16th August 2017

Detached double garage & single storey extensions to existing garage.
Harcourt West Drive Angmering

Thank you for your internet comments made on 15th August 2017 which has been recorded as **'an objection'** with the comments as follows:

<table><tr><td>PROJECT HARDCOURT West Drive, Angmering Littlehampton. BN16 4JE</td><td rowspan="4"> 29 Breach Avenue, Southbourne, Emsworth, Hampshire. PO10 8NB T: 01243 697164 M: 07879471666 www.pdkconsulting.co.uk</td><td rowspan="4"> PDK Architecture and Surveying</td></tr><tr><td colspan="2">DRAWING PROPOSED SITE PLAN</td></tr></table>

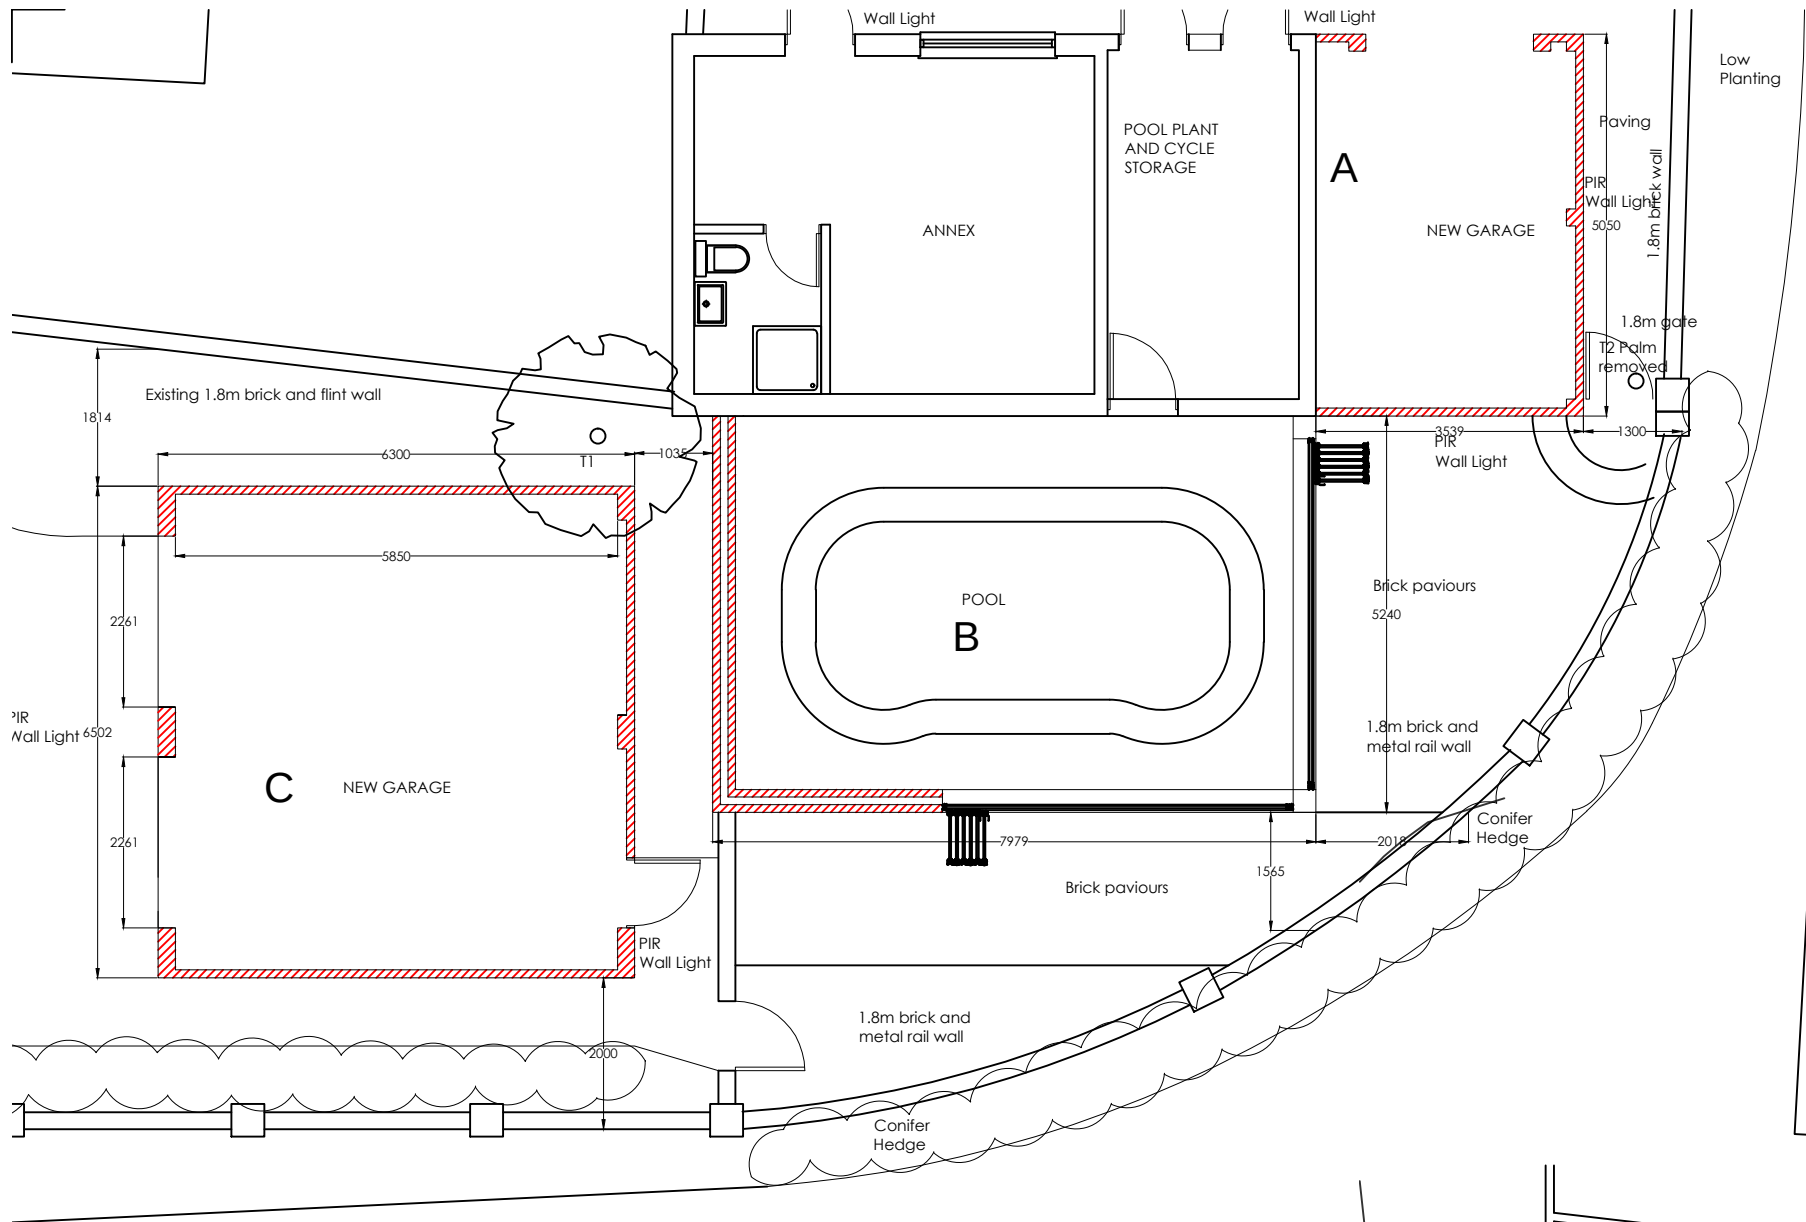
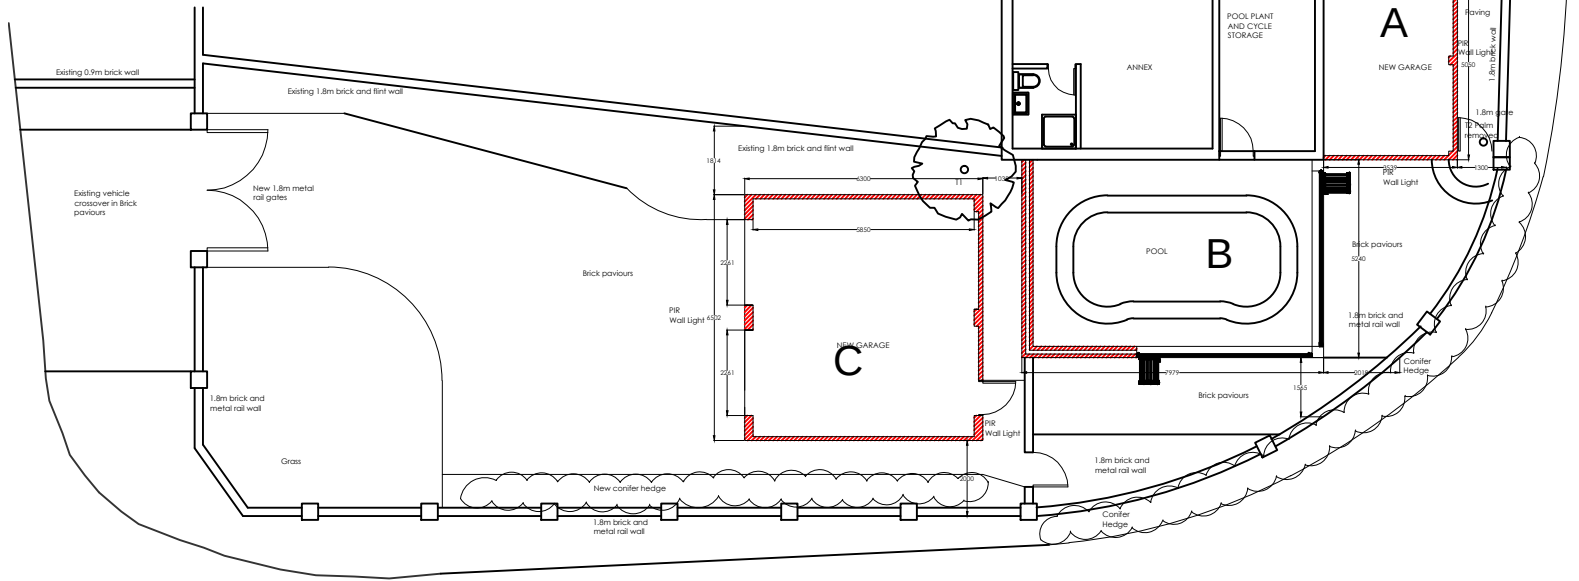
Considered at Housing, Transport & Planning Committee Meeting, 08/08/2017. Objection on the grounds of non-compliance with Neighbourhood Plan policies HD5, HD6 and HD7; impact on surrounding area in terms of flood risk; and highway safety for vehicles leaving the subject site and those exiting the Ham Manor Golf Club.
